**Planning Application 2026/90331 (Reference No 2026/62/90331/W)**

**Application for conversion of residential annex to 1No dwelling at 5 Park Riding, Northgate, Honley, Holmfirth HD9 6QL**

Drawing Title
Proposed Site Layout Plan

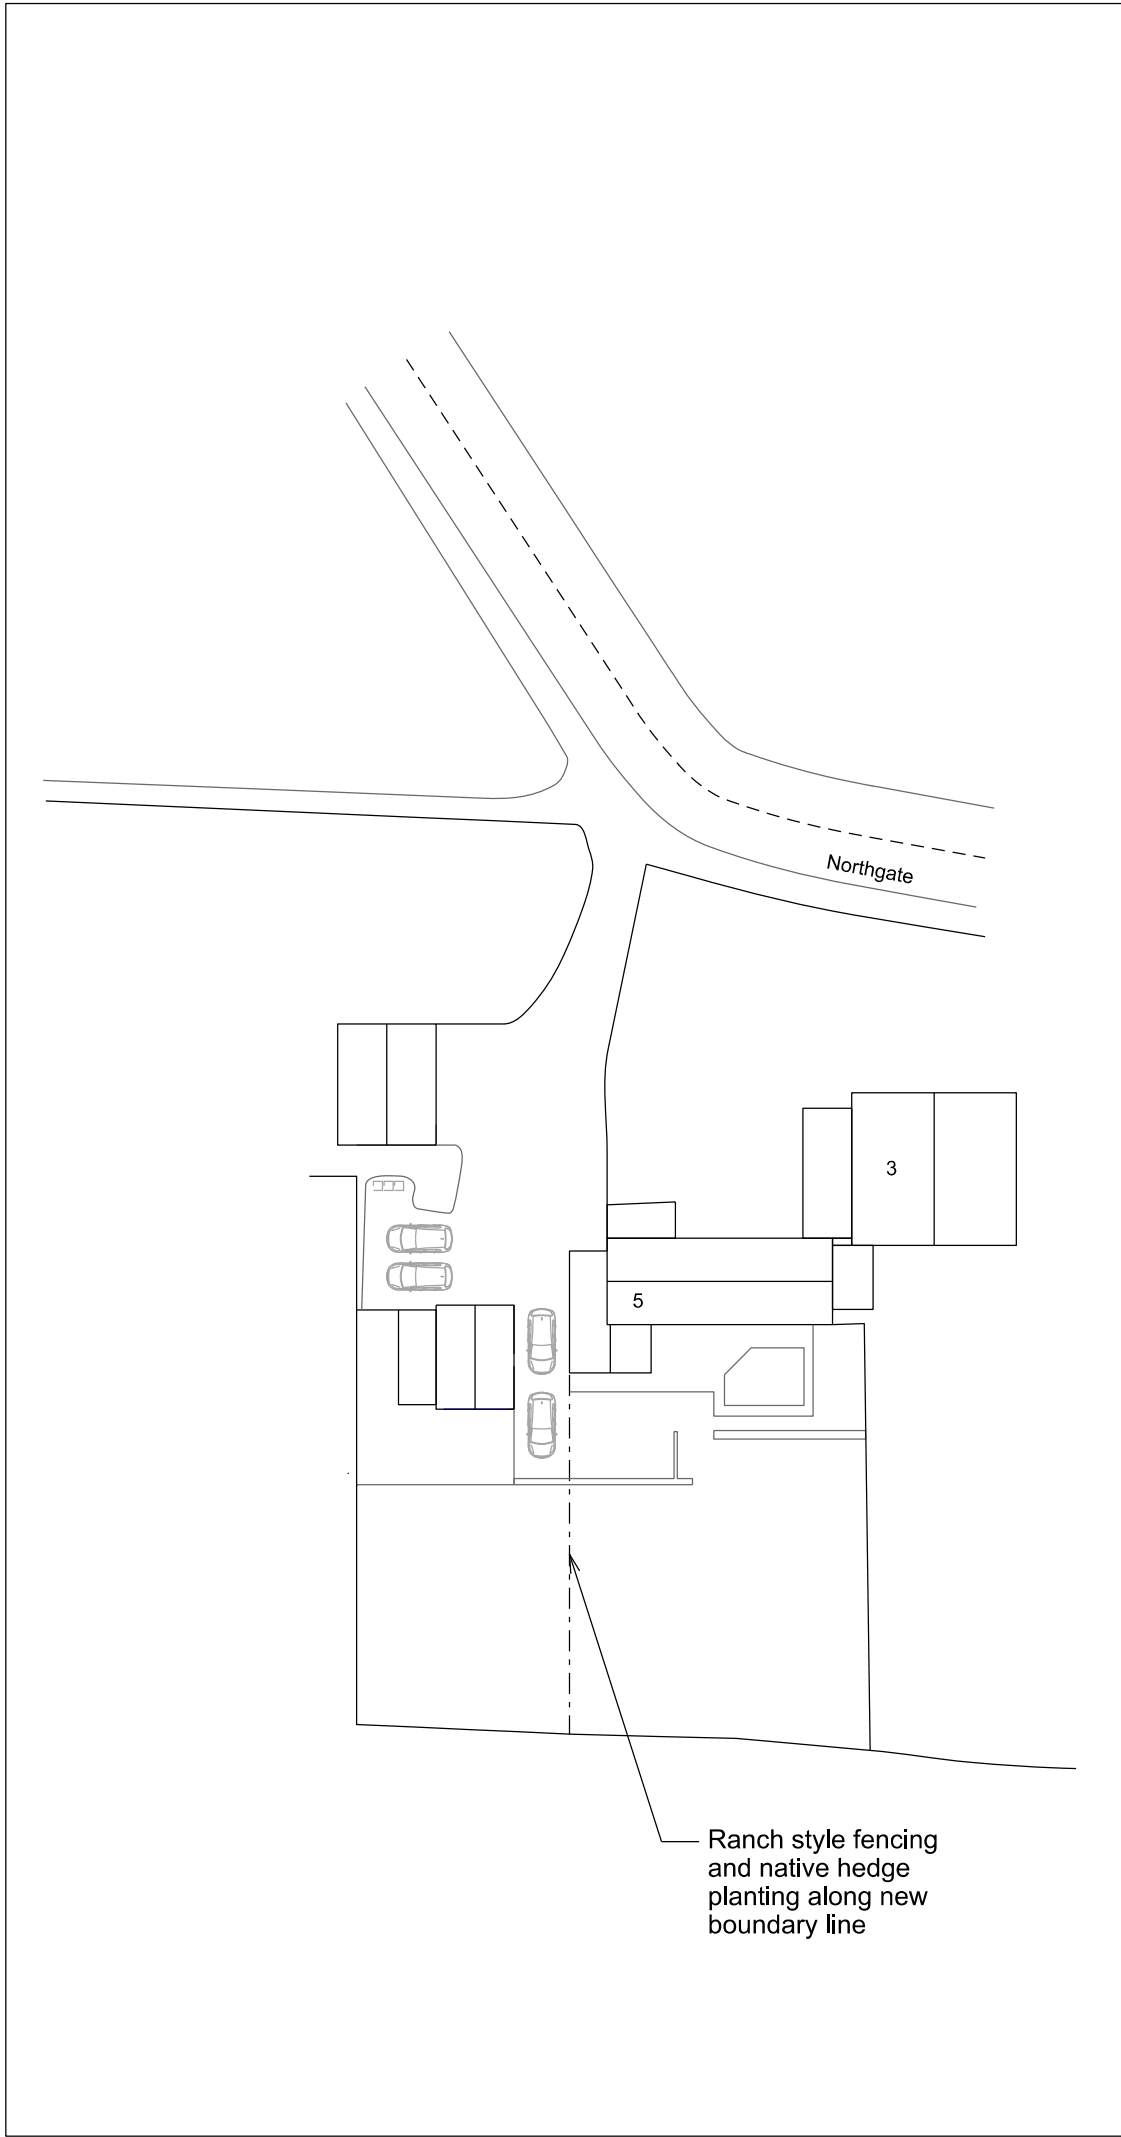
- The site layout plans attached to this application are misleading to the extent they fail to delineate all the boundaries of the land comprised within the ownership of the applicant. The site layout plans attached to this application are substantially the same as those submitted with the previous application in 2021 when the planning officer noted that the "curtilage has not been designated". The above filed plan clearly delineates the boundaries of 5 Park Riding and in particular the boundary across the driveway dividing the applicant's property from the adjoining property 3 Park Riding. This illustrates the confined nature of the development site at the front where there is only a small forecourt approximately 6 metres in depth within the curtilage of 5 Park Riding.

- Whilst it is accepted that the site layout plans may only be indicative, the site layout plans submitted do not clearly show how the land within the curtilage of 5 Park Riding at the front and sides of the applicant's property can be subdivided to accommodate two separate dwellings without detriment to the host dwelling. The close proximity of the host dwelling to the proposed dwelling and the small forecourt are insufficient to provide an appropriate level of privacy, freedom from noise disturbance, ease of access to each property and room for the storage of essential household items such as bins.

- The site layout plans are also misleading in that they do not accurately show the cramped nature of the site at the side of the proposed dwelling. The footprint of the proposed dwelling shown on the site layout plan is actually that of the former garage and outbuilding and does not show the full extent of the footprint of the extended annex which abuts directly onto the field, part of which is in our ownership.

With regard to the site layout plans we do not agree to the driveway in our ownership being shown within the red edging. The development site which is the subject of this application lies wholly within the curtilage of 5 Park Riding and suffice to say that the applicant only enjoys a right of way over the driveway as access to her property.

Furthermore, contrary to the comments made in paragraph (ii) of the applicant's covering letter, the applicant has again failed to fully define all the boundaries of her property on the site layout plans and has also failed to show accurately and precisely the full extent of annex which abuts directly onto the adjoining field, part of which is in our ownership..

Drawing Title
Proposed Site Plan

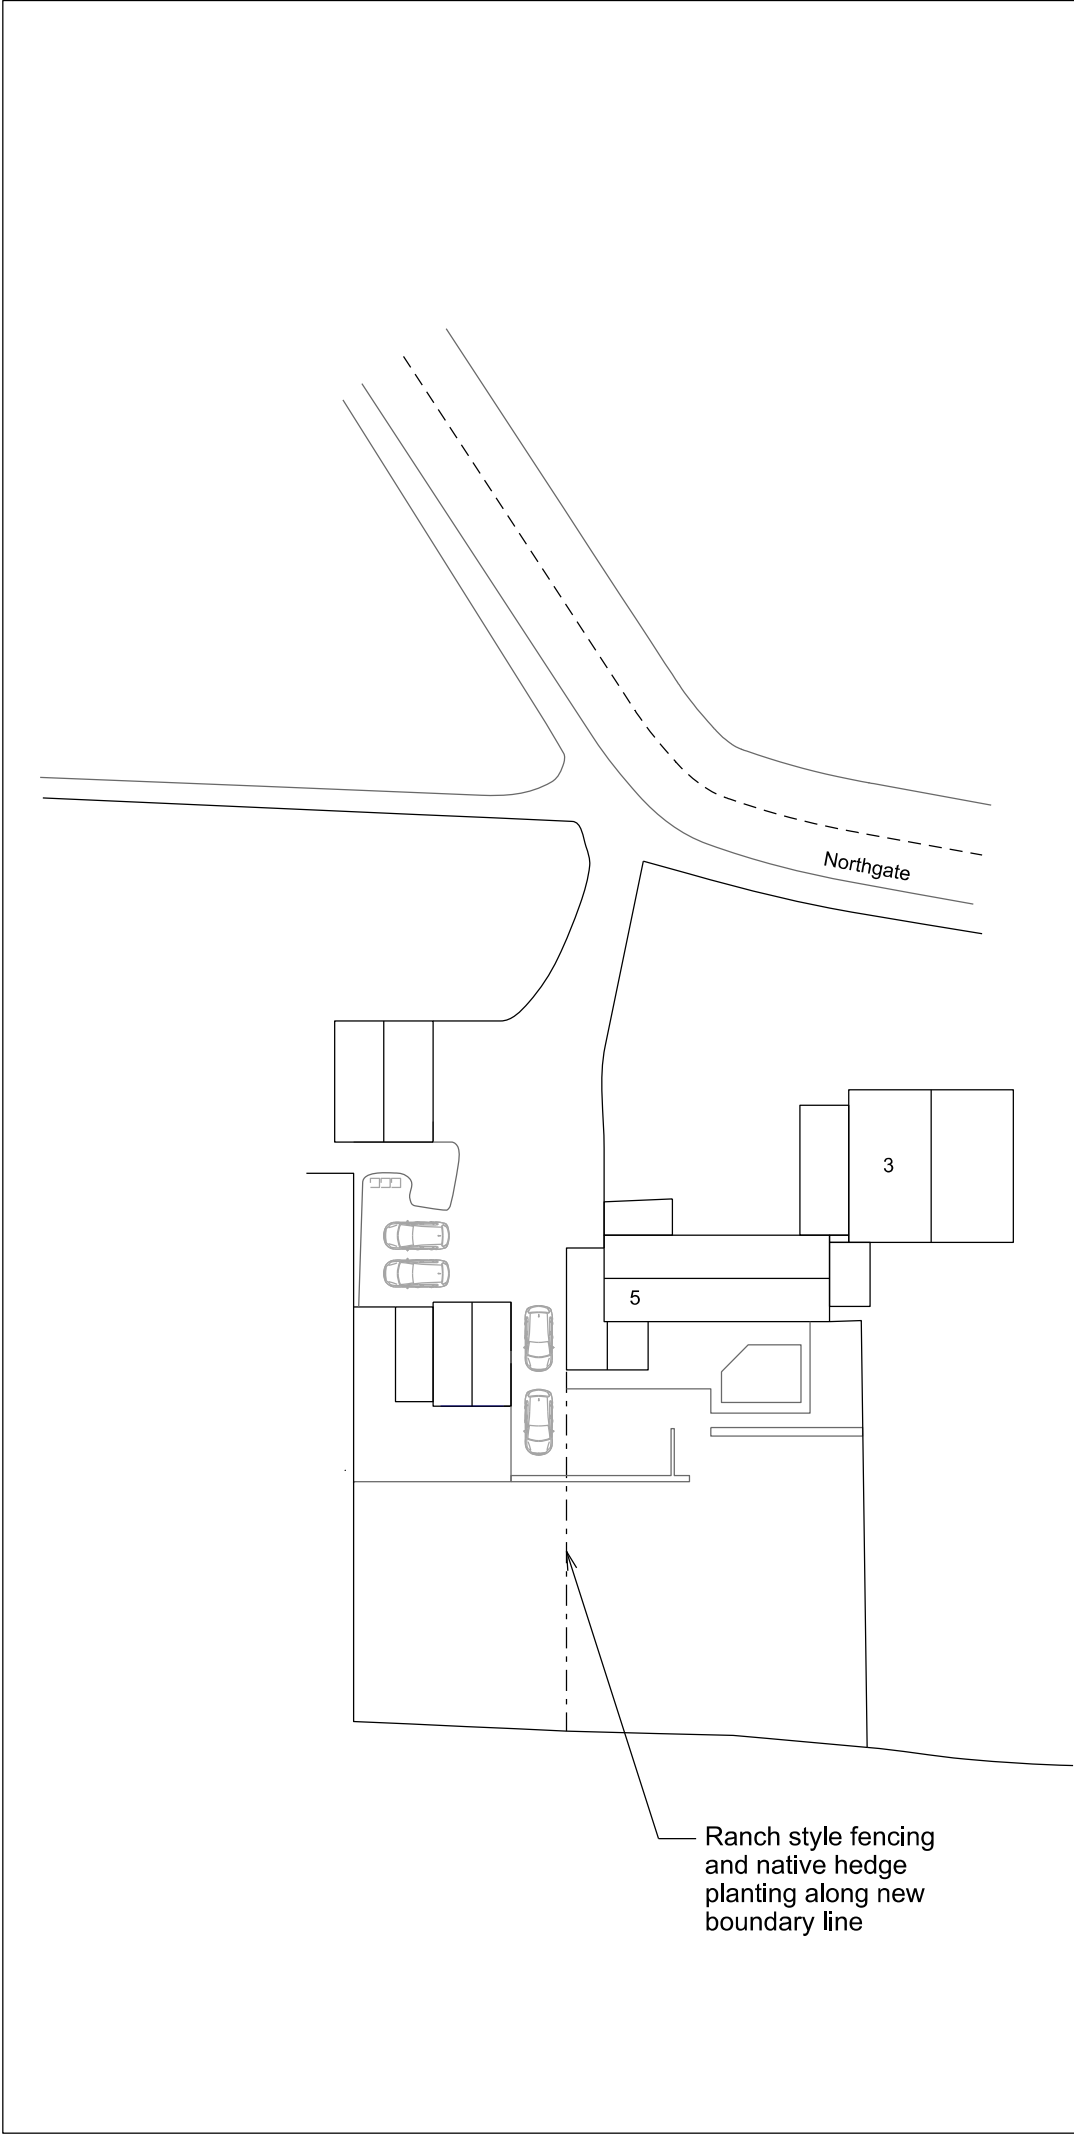
- As previously explained, the site layout plans provided by the applicant do not fully identify the legal ownership of the land within the red line. This is important as the Planning Support Statement lodged with the application states that "The subject site is accessed via a private driveway which opens up into a courtyard and provides parking for the two extant dwellings (5 Park Riding and 3 Park Riding) and the subject annex". It also states that the parking arrangements for the host dwelling and proposed dwelling will "remain within the existing courtyard as shown on the submitted plans" (Page 4).

These statements are misleading as there is no communality of ownership over any part of the driveway between 3 Park Riding and 5 Park Riding with each property having exclusive ownership of that part of the driveway within the curtilage of their respective properties. In particular, it is important to note that:

- The applicant only has a right of way over that part of the driveway in the ownership of 3 Park Riding as shown coloured yellow on the attached site layout plan (Appendix B). The owners of 3 Park Riding do not have corresponding rights over the land within the curtilage of 5 Park Riding.
- It follows that the expression "courtyard" must be construed as being limited to the forecourt within the curtilage of 5 Park Riding as previously defined and that is the only area available for parking their vehicles.
- Neither the applicant nor the owners of 3 Park Riding have any right to park wholly or in part on the driveway shown yellow on the above plan.
- Any indiscriminate parking on the driveway shown coloured yellow on the above plan would prevent the manoeuvring of vehicles requiring access to and from 5 Park Riding. In
